Application Reference: 2025/0785.

Location: 4 Whinmoor View, Silkstone, Barnsley, S75 4LL.

This application seeks planning permission for the erection of a raised patio extension to an existing rear extension erected as permitted development.

**Side Elevation**  
1 : 50

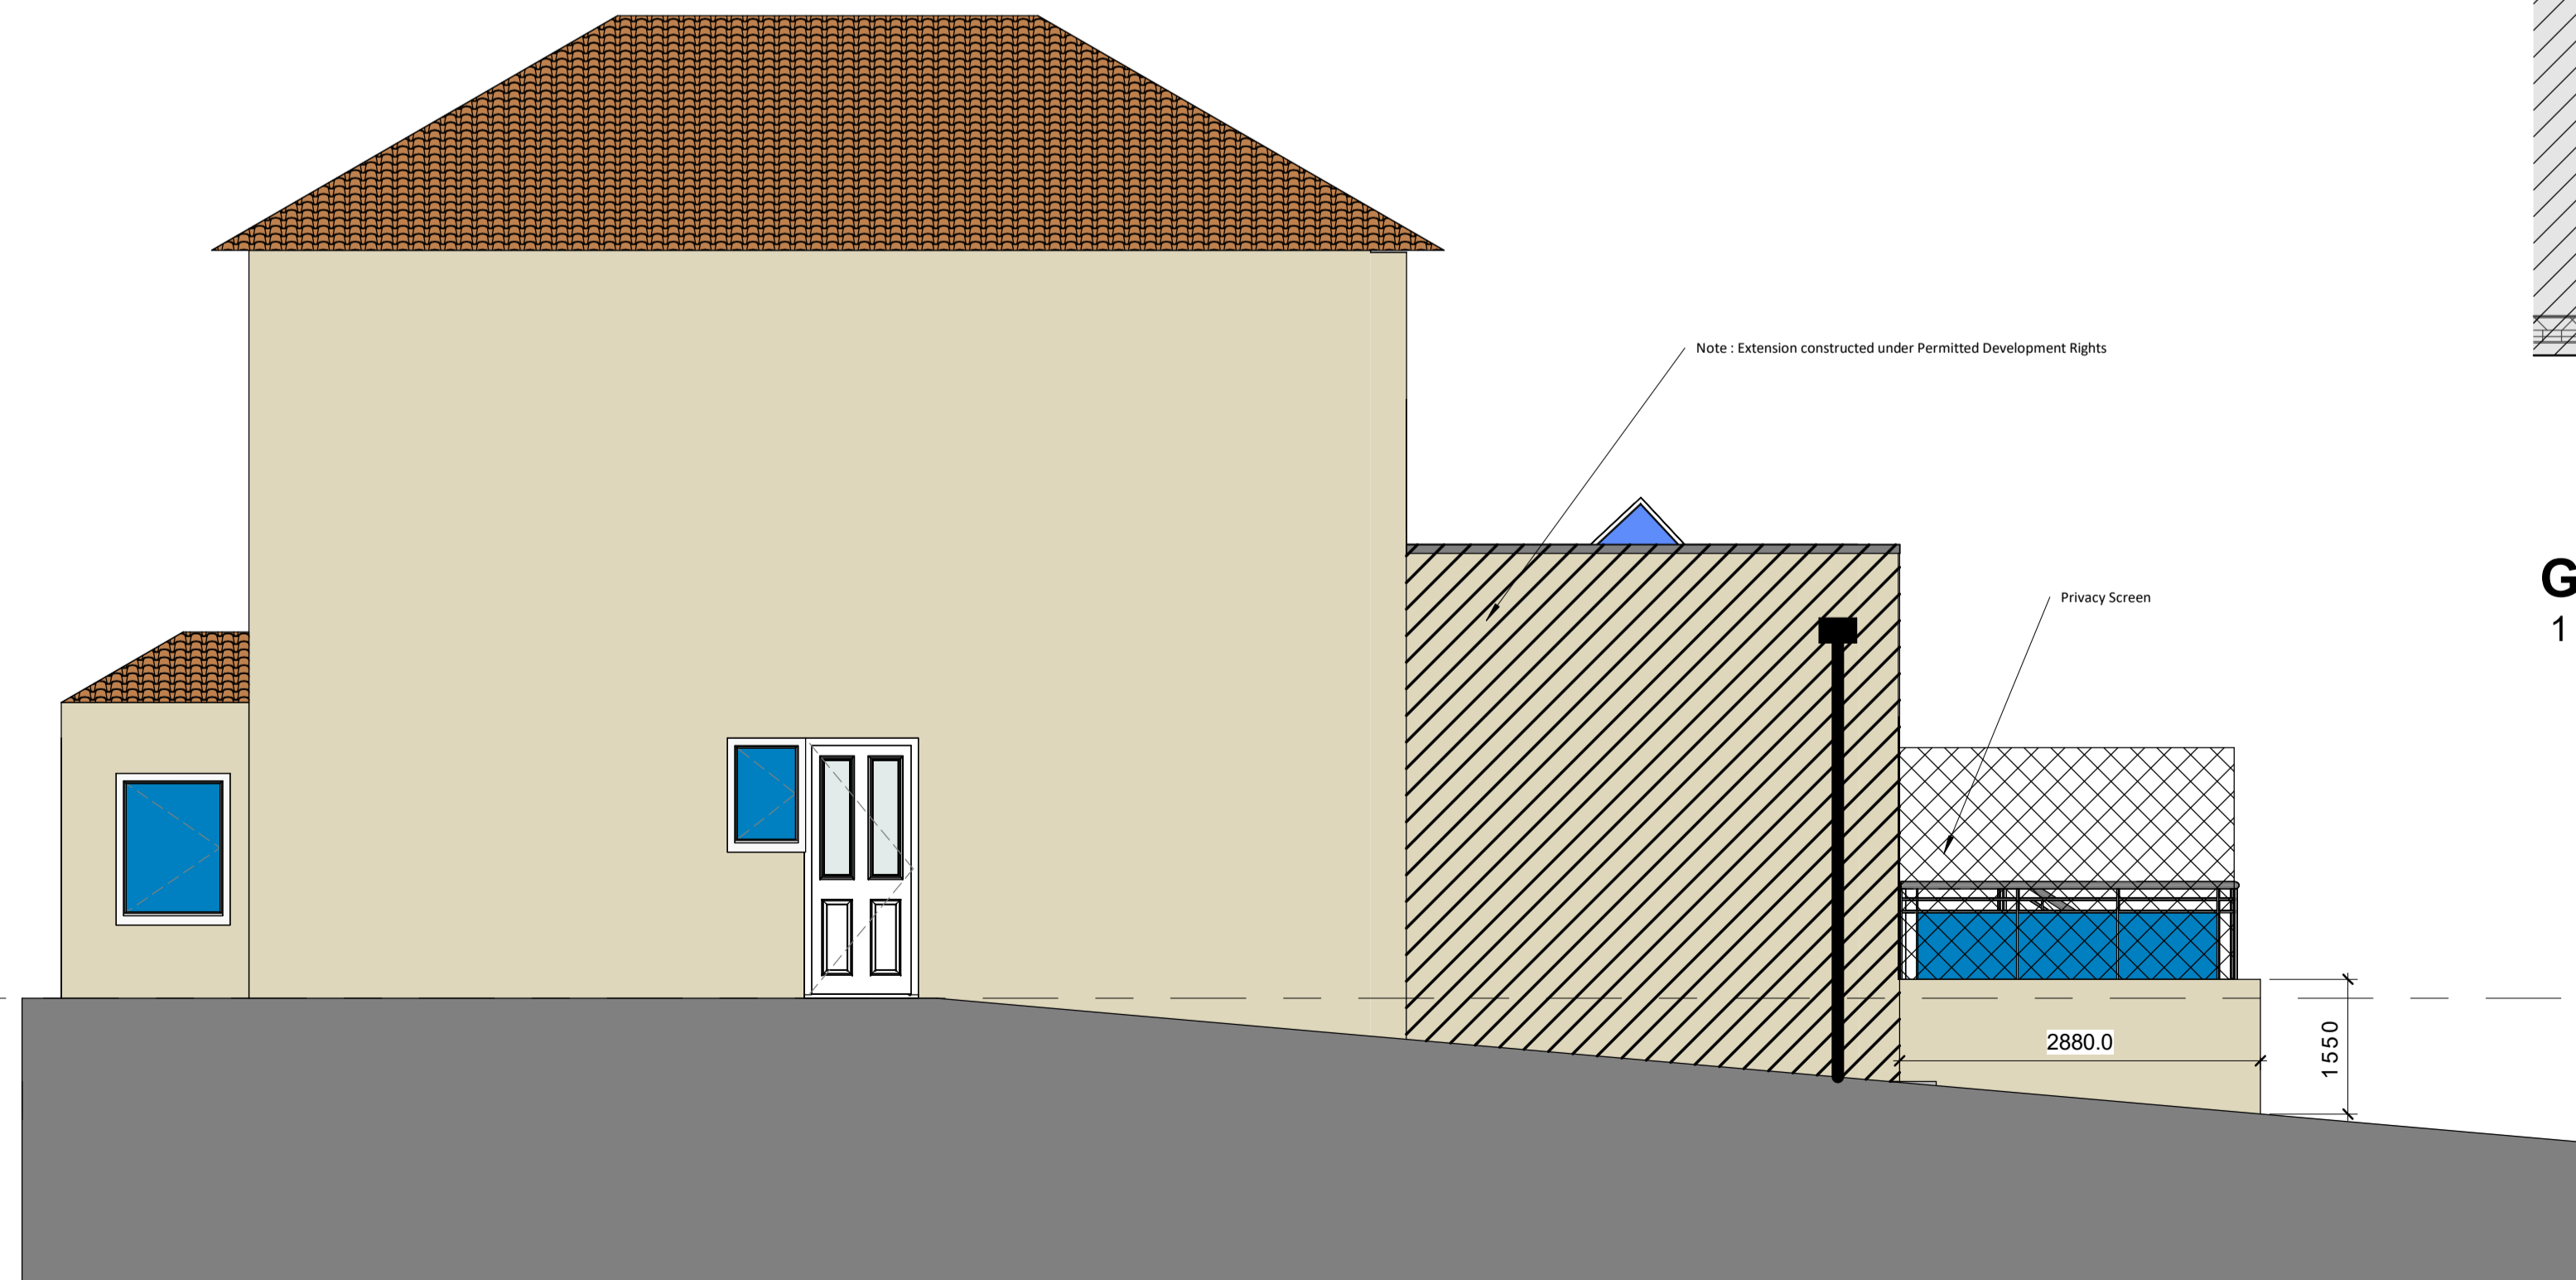
A 1.8-metre-high privacy screen is proposed on the south-east side of the raised platform. While this is shown as a trellis-like screen on the submitted plans following discussions with the Applicant it is understood that a solid composite screen (or similar) would be erected. For the avoidance of doubt a solid screen could be secured by condition should this application be approved.

Notwithstanding the above, potential amendments were suggested by the LPA to the Applicant such as setting the raised platform and privacy screen in from the side elevations of the rear extension to the application dwelling and re-locating the steps to the rear. A height reduction was also considered by the LPA. However, the Applicant decided to proceed with the application as submitted and without amendment. The LPA cannot enforce amendments upon the Applicant and therefore must consider the proposal as submitted.

- Amendments were sought to provide a set in from the side elevations of the rear extension, the re-location of steps to the rear and additional screening. The Applicant decided to proceed with the application as submitted and without amendment.
